REPORT UPDATE

Application No: BR/179/14/PL

Recommendation Report for Planning Permission

PROPOSAL: New 3/4 bed dwelling & minor alterations to no.33 Shelley Road. Resubmission of BR/306/13

scale
 1:100 1:200 date 06.2014 drawn
 drawing ref number
 site ground and roof floor plans 2858A/3/5

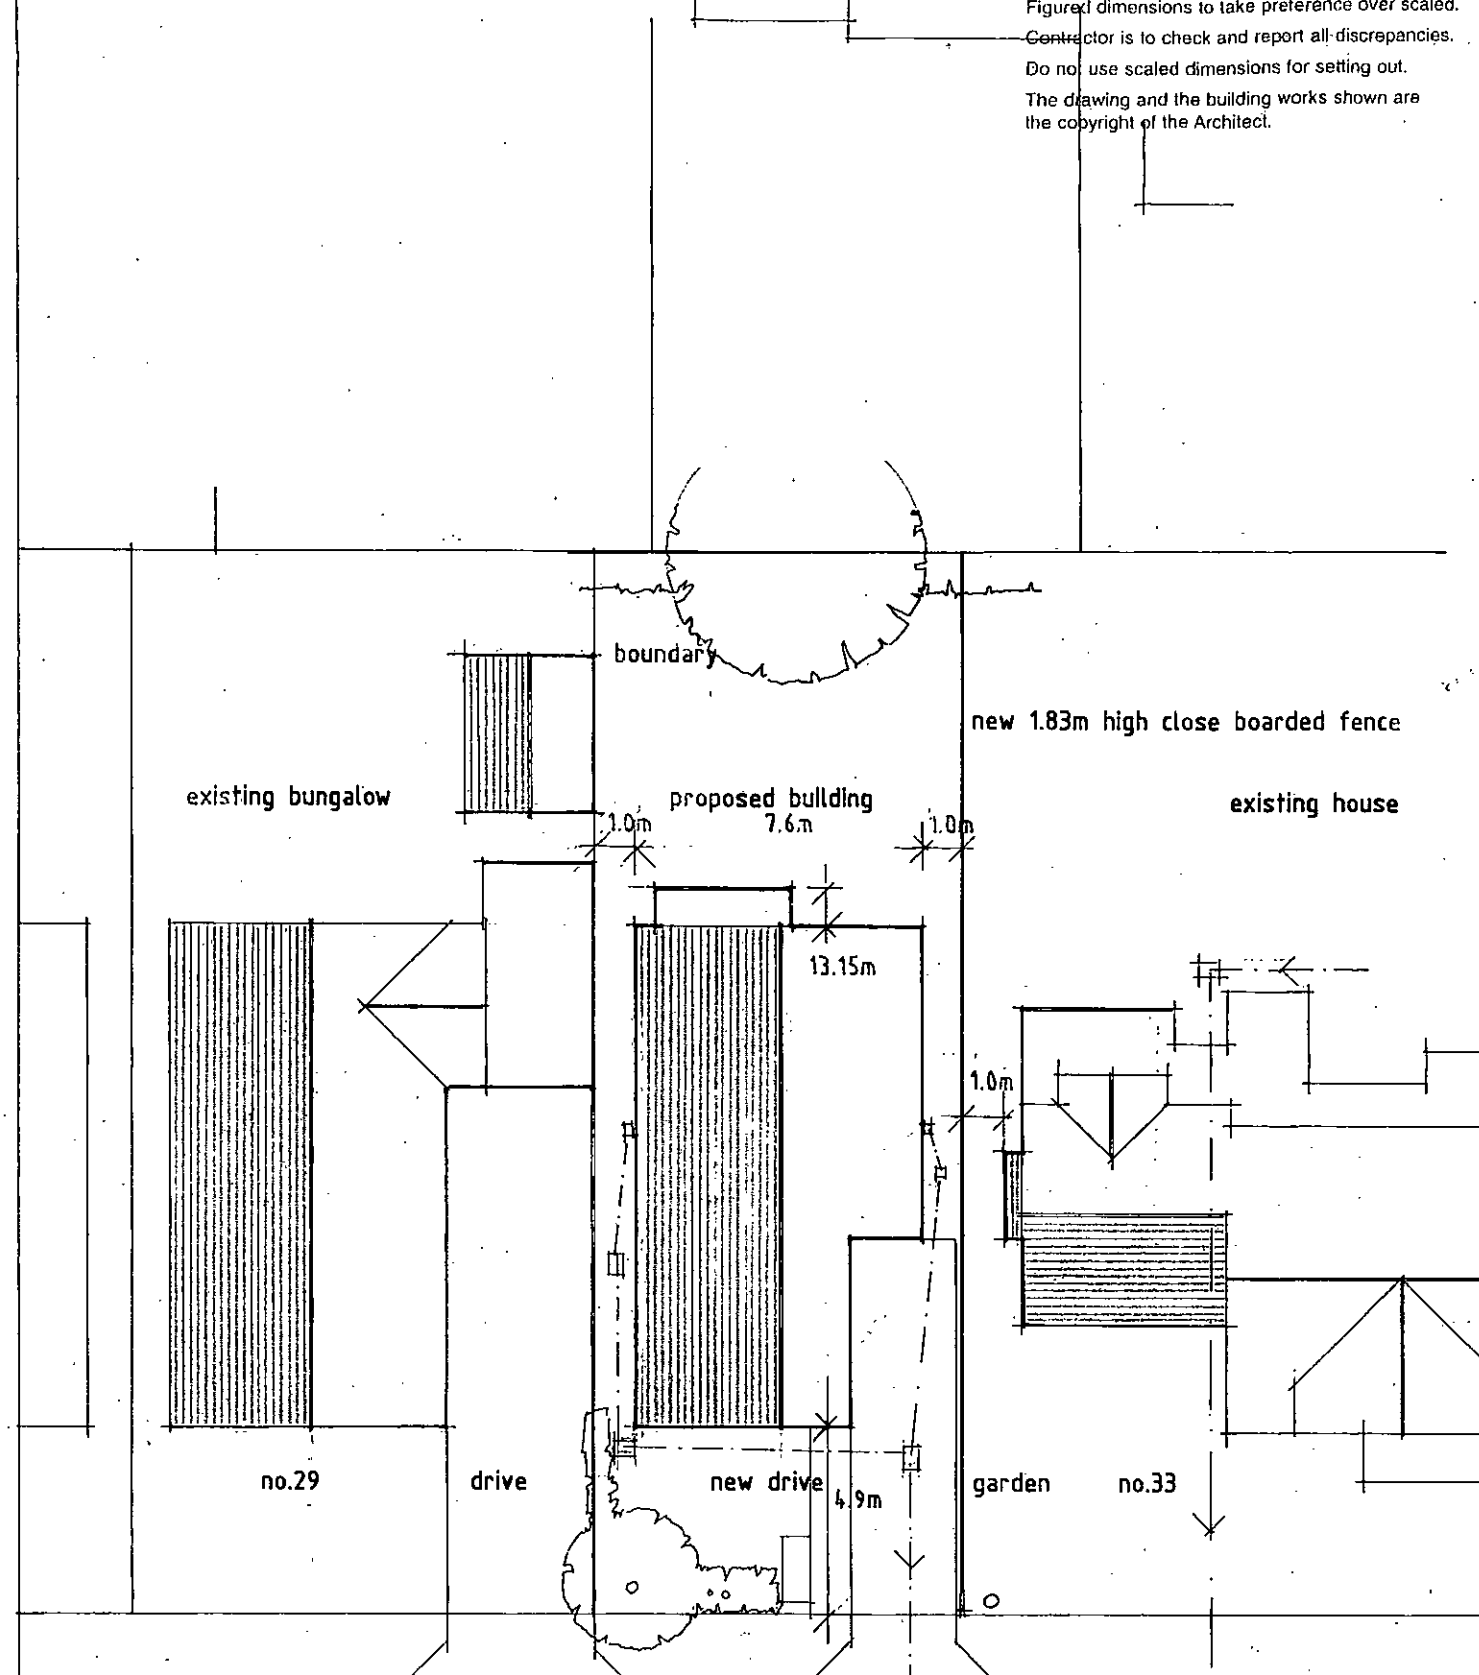
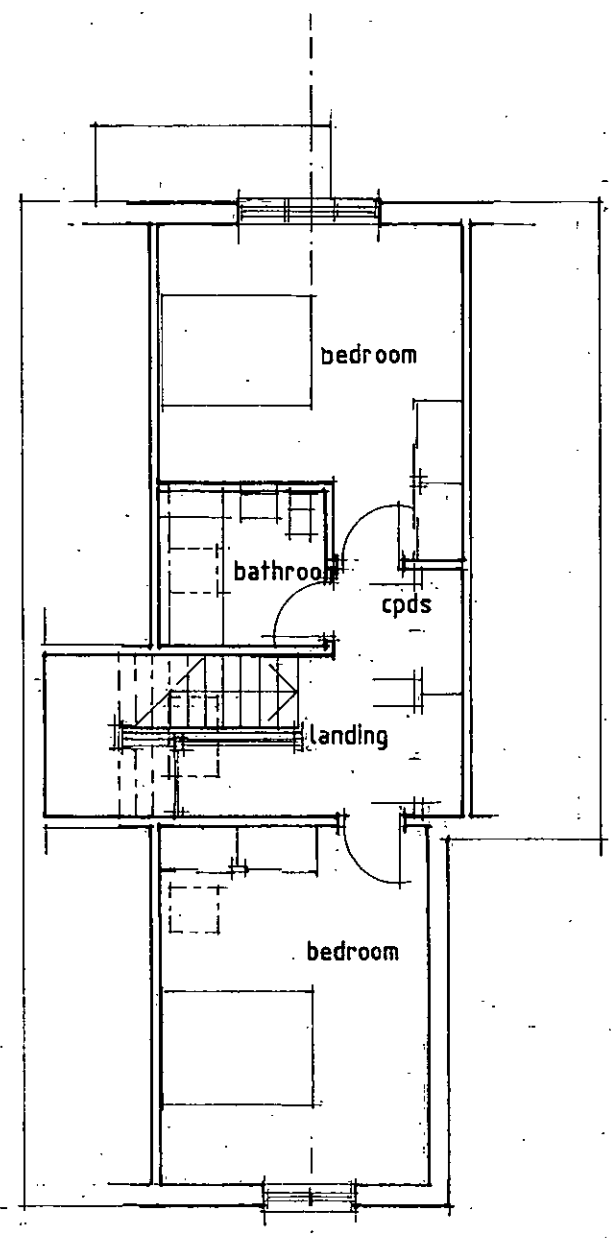
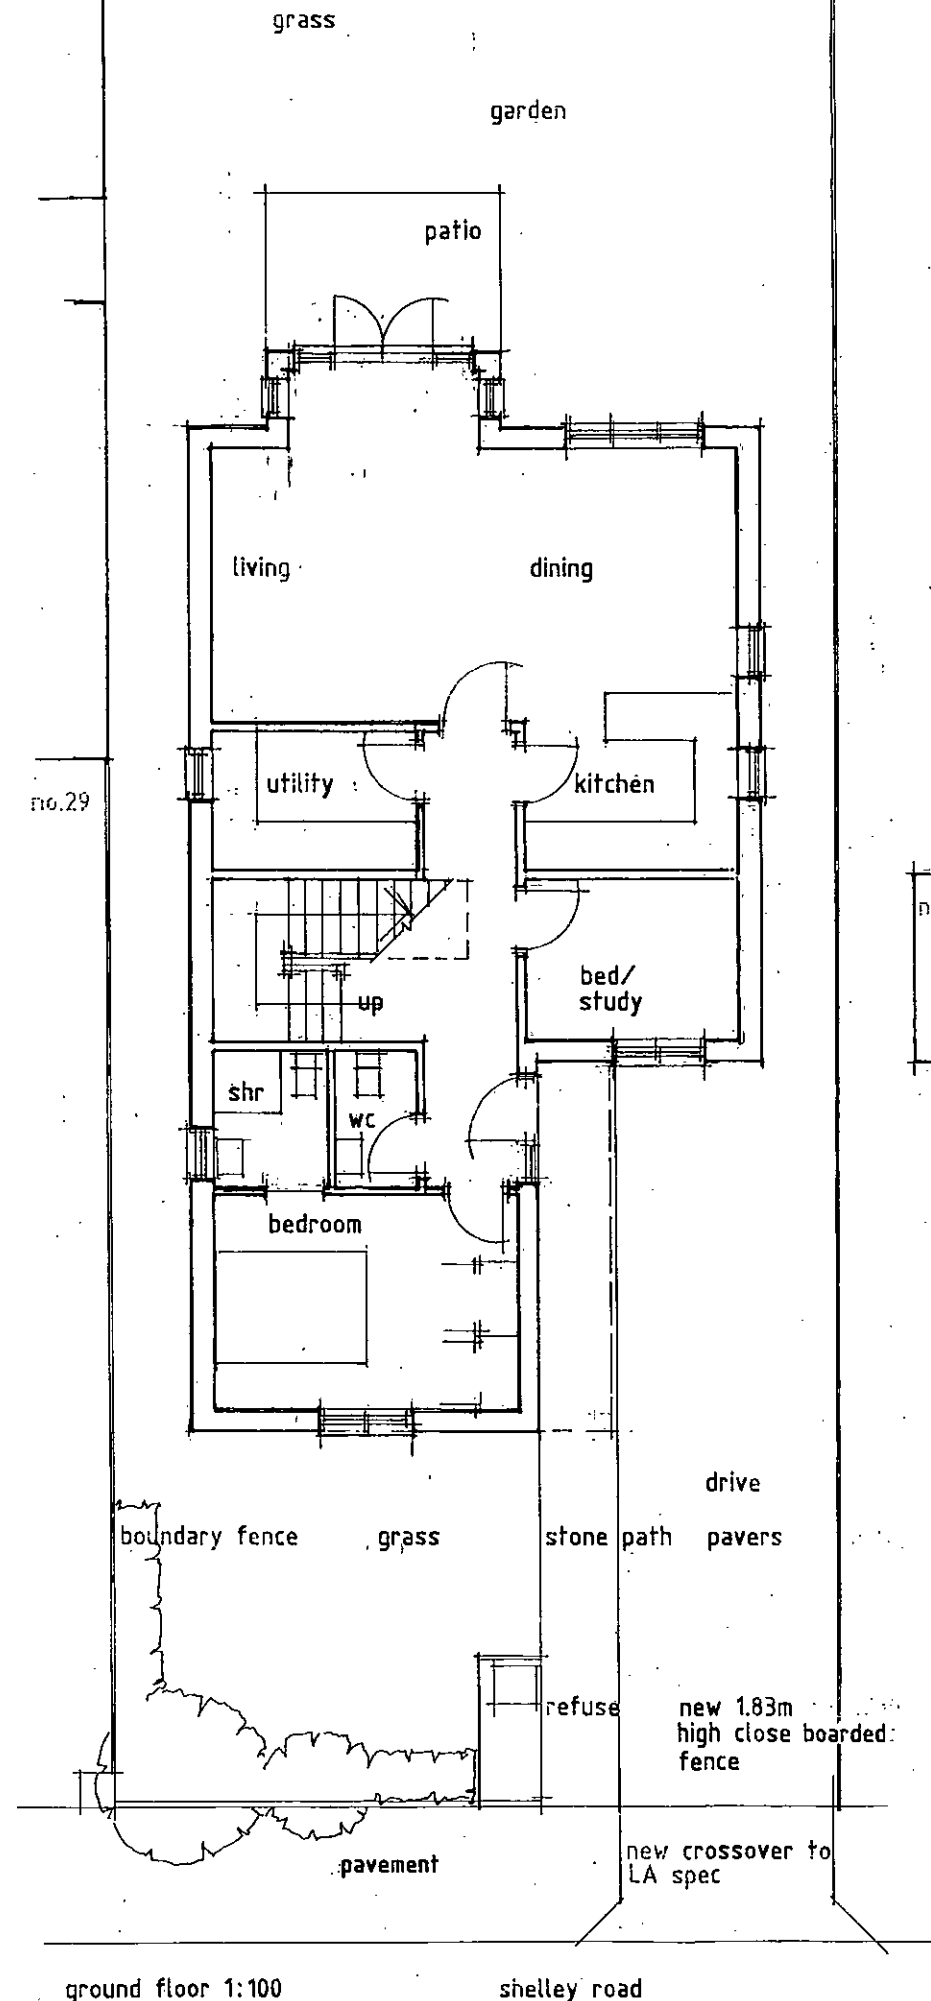
Roof lights to the side next to no.29 have their eaves at eye height so that the view is toward the sky and not over no.29. Again the windows belong to secondary uses (bathroom and stairs) and to a limited use room i.e. a bedroom."

The proposed building has been reduced in size since the first application. Also, the site is currently garden land for no. 33 but the garden retained to the rear is sufficient for the existing dwelling. No overlooking will occur as the windows on the side facing 29 are either obscured by boundary treatment or high level velux roof lights.

It is not considered that the proposed dwelling will create any adverse overlooking or result in a loss of privacy to either of the neighbouring dwellings. In this regard, it is noted that the ground floor flank windows will be screened by the boundary treatments and that the first floor velux roof

lights on the eastern roof plane are high level and serve to provide light not to allow for people to look out of them.

scale 1:100	date 06.2014	drawn
drawing ref section and elevations	number 2858A/3/6

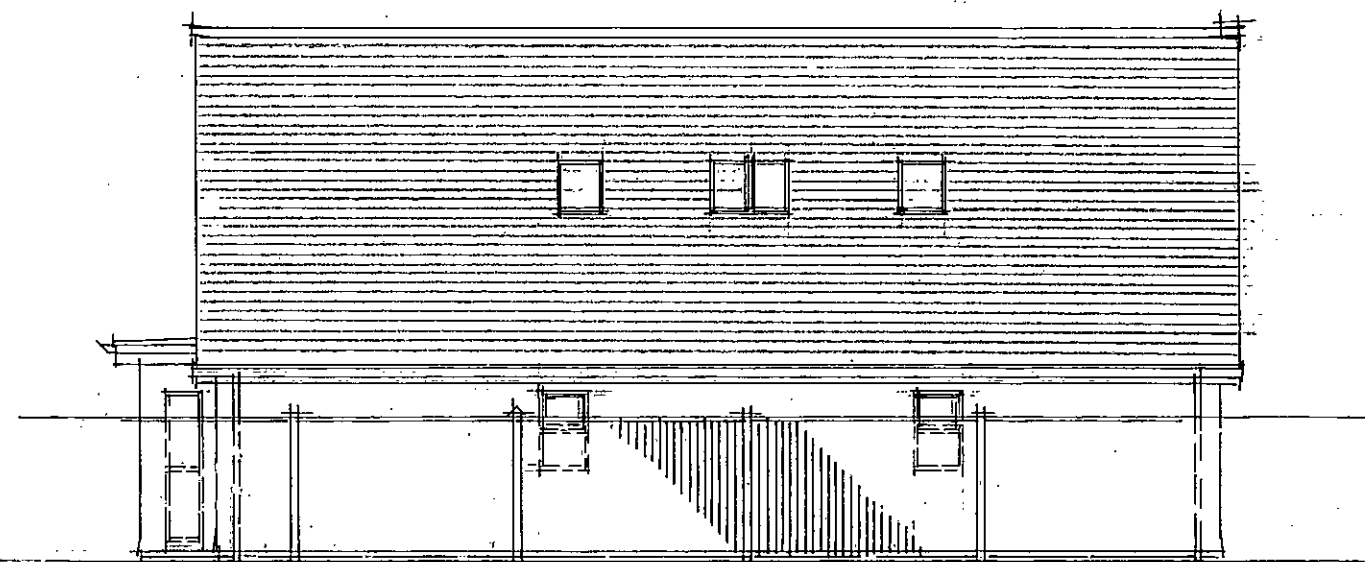
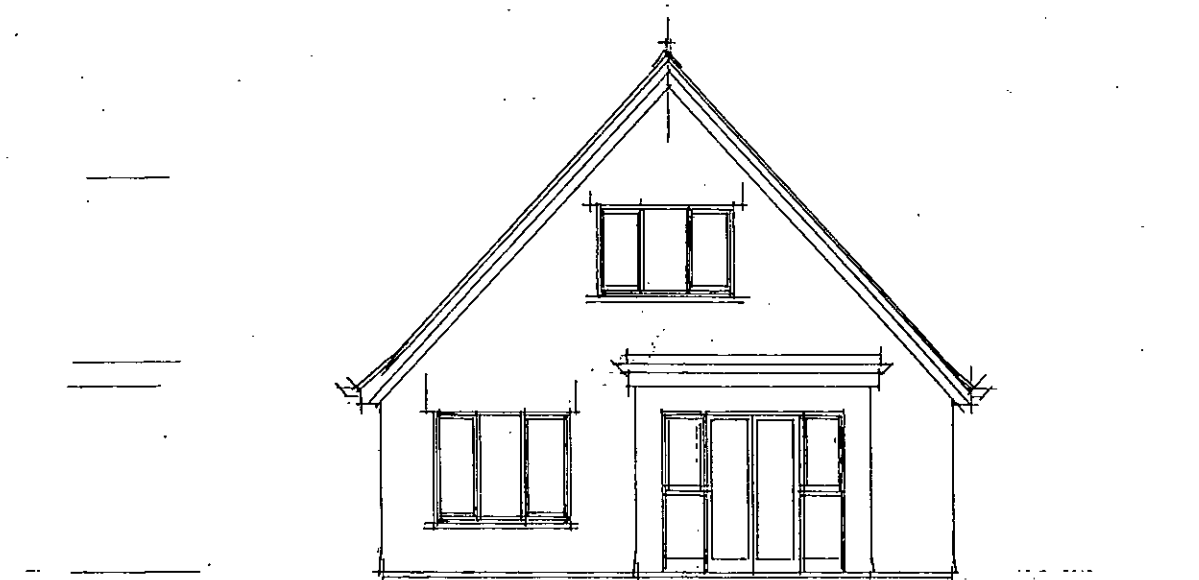
The proposed house has been designed with a pitched roof & pitched front gable which is considered to be in keeping with the Edwardian character of the street. The design provides a visual blending between the properties either side by using the same roof pitch and front gable as 33 but also copying the eaves height of the bungalow at 29.

With regard to light, whilst the previous proposal was considered to impact on the amount of sunlight available to the neighbouring bungalow (29), it is considered that due to the changes and in particular the lowering of the ridge and eaves levels, that the new dwelling will not have such an impact. It is considered that this is reflected by the lack of any objection this time around from no. 29. Light was also considered previously to be an issue with regard to no. 33 but again the impact has been reduced due to the change in the building height. Furthermore, the first floor flank bedroom window in no. 33 is only secondary and therefore the bedroom will still receive light from the south facing window.

drawing ref. street elevation and plans and elevations of no33 number 2858A/3/7

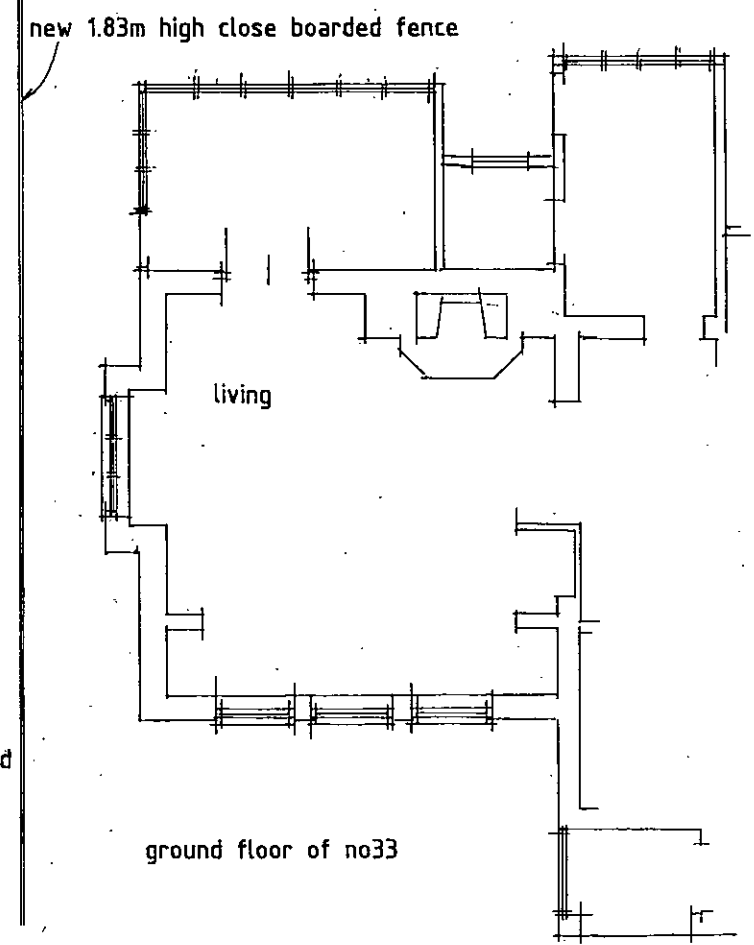
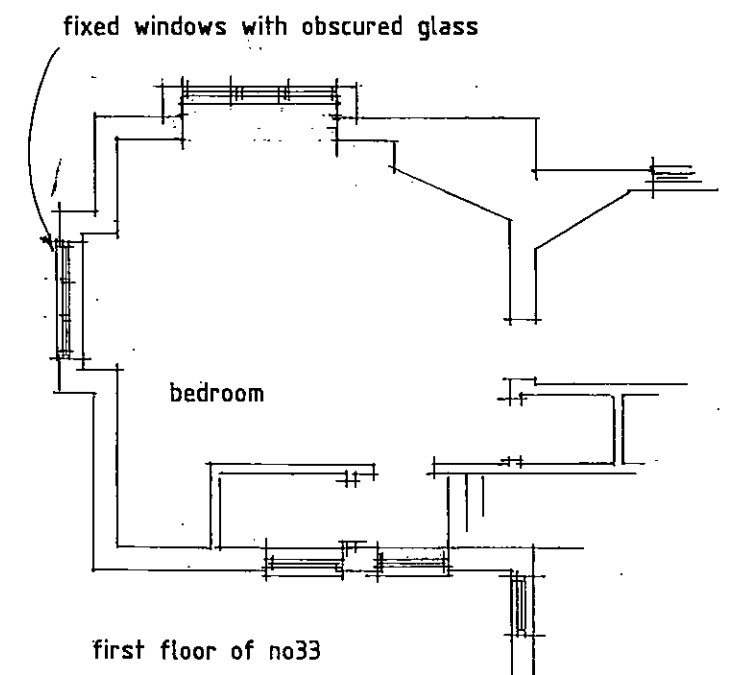
- 9 The bedroom window on the side east elevation of no. 33 Shelley Road shall at all times be glazed with obscured glass and fixed to be permanently non-opening.
